From: Michael Eastham
Sent: 03 November 2017 07:53
To: Planning.Responses
Subject: A/99/17/OUT - Land South of Water Lane, Angmering

Cc: Zoe Knott; Chris Fry; Adam Ross; Natasha Bullen
Subject: Re: Email 3: South of Water Lane, Angmering

Tree Protection Plan

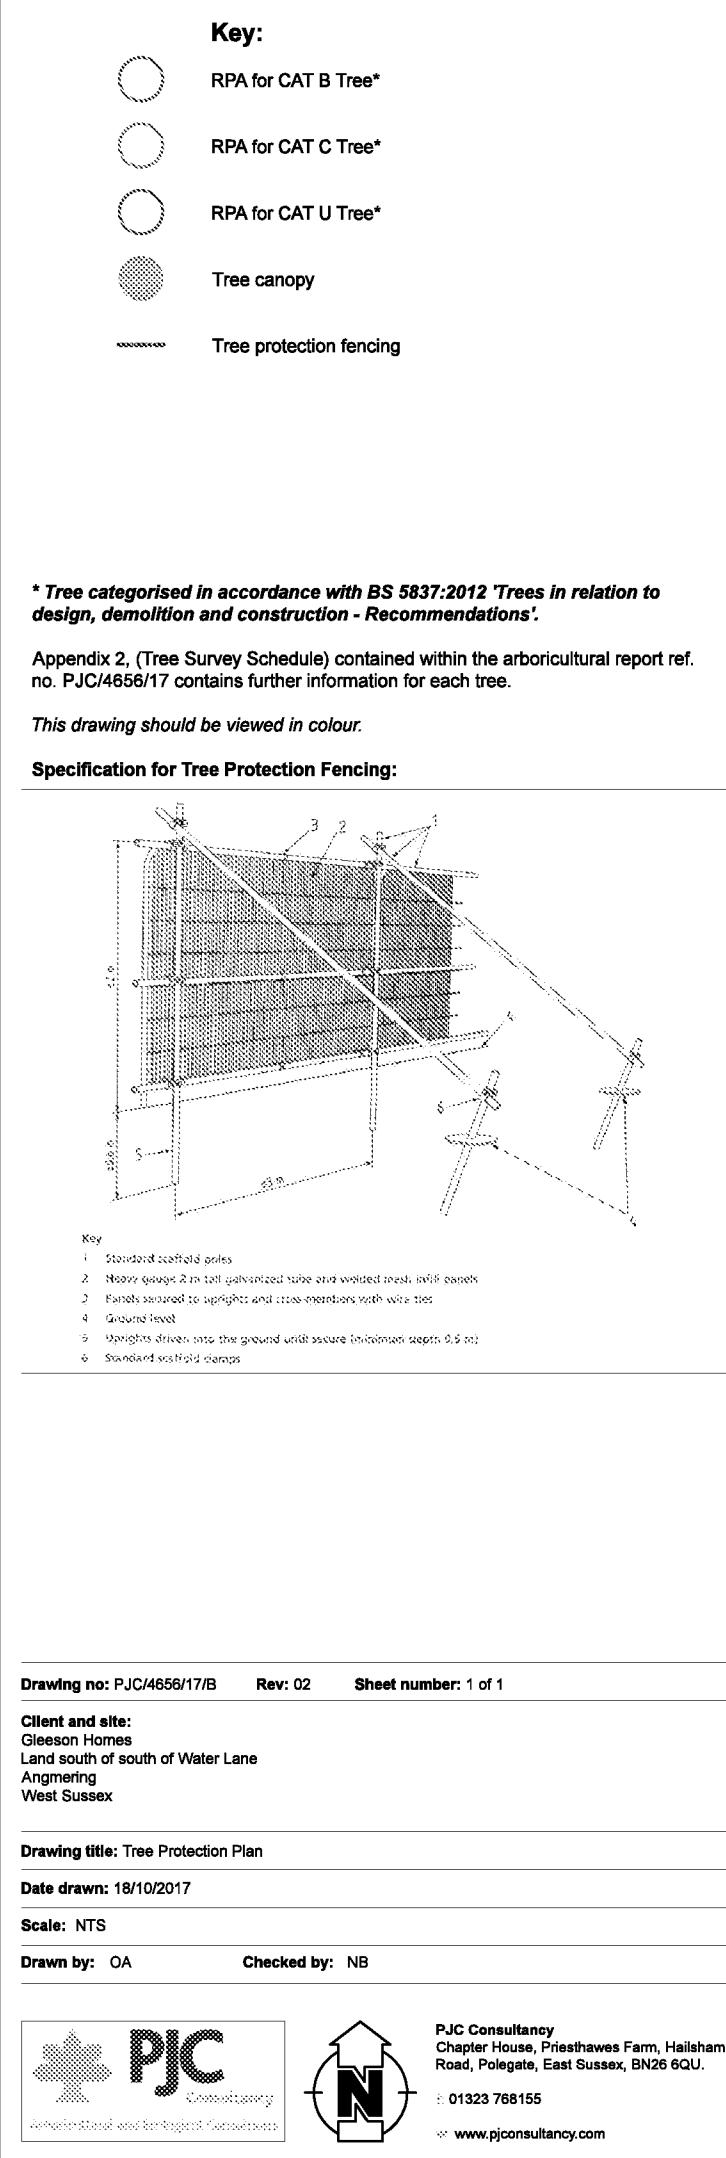
- Layout amended to reduce pressure on G31 by houses at the northern boundary.
- Repositioning of a 'large block' to limit impact on T37 which is not evident on my current AIA. This point may require clarification by Nexus / Pro Vision.
- Updated AIA containing several (tree retention plans only) at a scale that can assist the reader in observing impact and removal of Tree protection plan which should be approached as part of a detailed AMS at full application come the time.
